Recommendation Report for Planning Permission for Works or Extension to a Dwelling

REF NO: LU/297/21/HH

LOCATION: 4 Esmonde Close
Littlehampton
BN17 6DZ

PROPOSAL: Erection of single storey side, rear and front porch extension and loft conversion with 1 x rear dormer

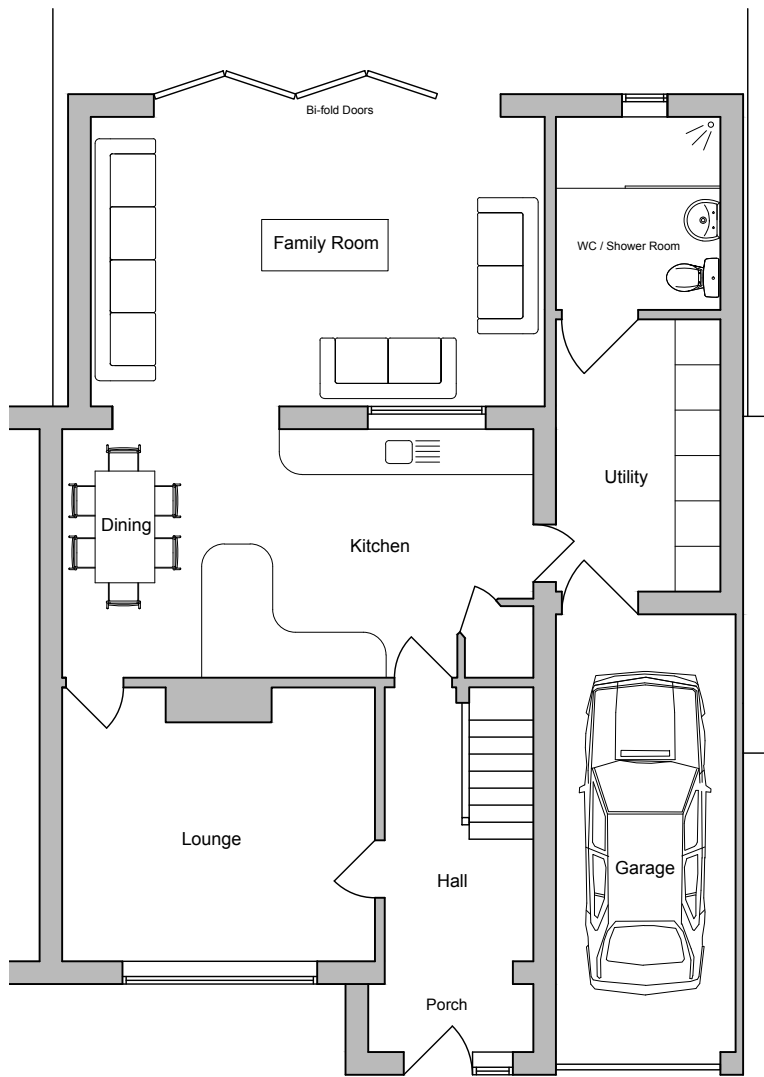
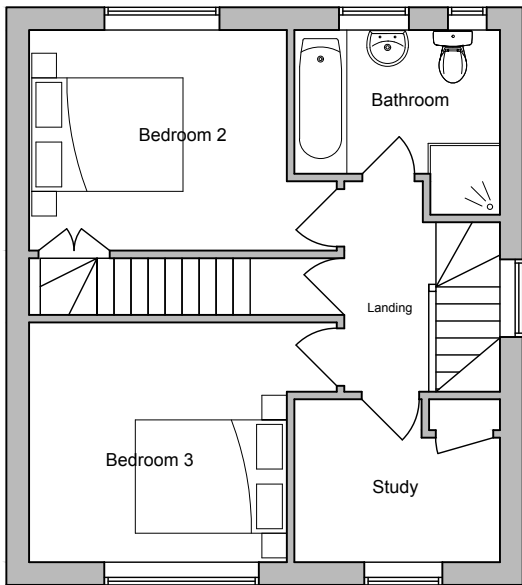
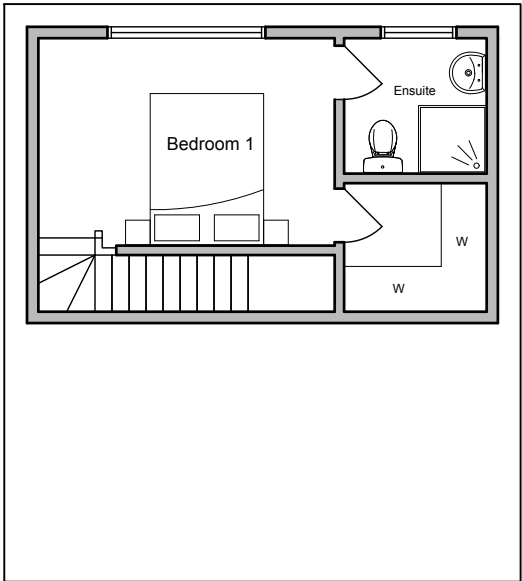
The applicant proposes to demolish existing rear and side extensions and replace them with a 'L' shaped rear and side addition, including a small extension to the front to form a porch. Although a larger scale project, the combination of 2 other built structures into one new one is seen as a positive addition to the host dwelling.

In terms of over looking, the extension will only have windows at ground floor level and which face towards the rear private amenity space and towards the front and the public realm, where it is generally accepted that there are no negative impacts from overlooking.

The dormer roof extension will sit within the external footprint of the host dwelling and as such it will not overbear or overshadow neighbouring properties.

The proposed windows at first floor level will face towards the rear amenity space, there is a 30m separation distance between the external face of the dormer and the rear of the property backing onto the application site, as such it is considered that there will be no negative impacts from overlooking from the second floor windows.

Rev	Notes	Date
 NAT Design <u>Architectural Services</u> 23 Mill Road Angmering BN16 4HT Tel: 07599 199759 E: info@nat-design.co.uk		
Project: 4 Esmonde Close, Littlehampton, BN17 6DZ		
Drawing: Proposed Elevations		
Drawn by NSE		Scale as shown
Date Aug 2021		Revision
Drawing 851 - DPA - 06

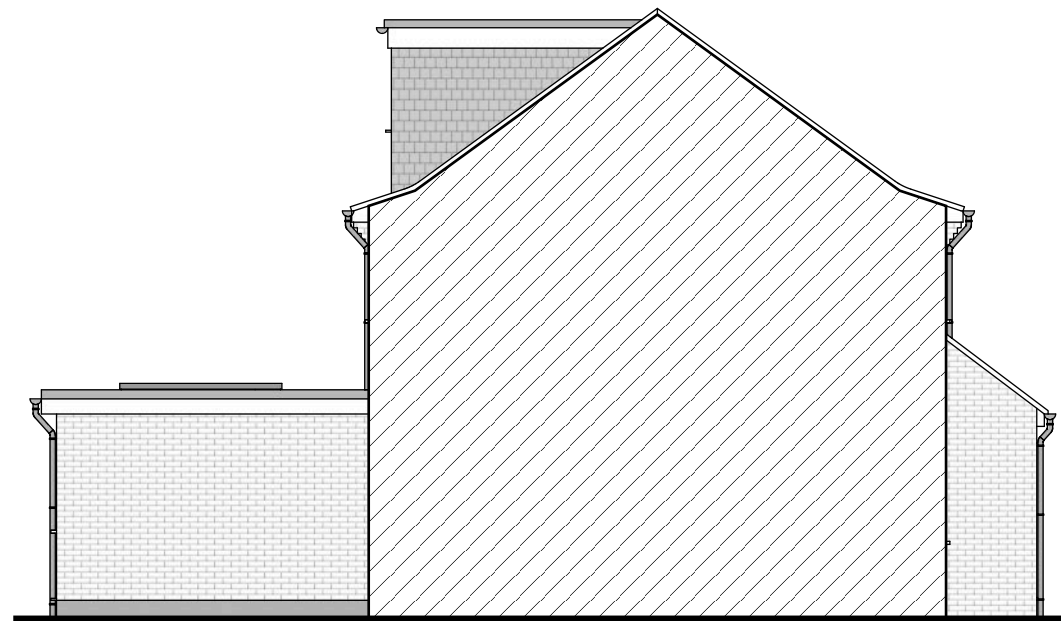
The extension will be built from materials which match those currently found on the host dwelling and with an eaves and roof height considerably lower than the two storey dwelling will make the proposal well integrated with the property.

From the street the porch and side extension, which will form a garage, will be visible. The porch and garage will sit forward of the primary elevation by approximately 1.2m. Other examples of porches can be found at Nos.7 and 12 Esmonde Close and a garage extension which sits flush with the existing frontage can be seen at No. 9 and No. 16 which has had a large front extension that includes a new porch and increase living space to the front of the property. It is therefore considered not to be out of character with the street scene and subservient to the dwelling.

The rear dormer roof extension will be constructed with materials which match and to a size and scale that could be constructed under the properties Permitted Development Rights. However, due to its position and scale it is well integrated and subservient to the host dwelling.
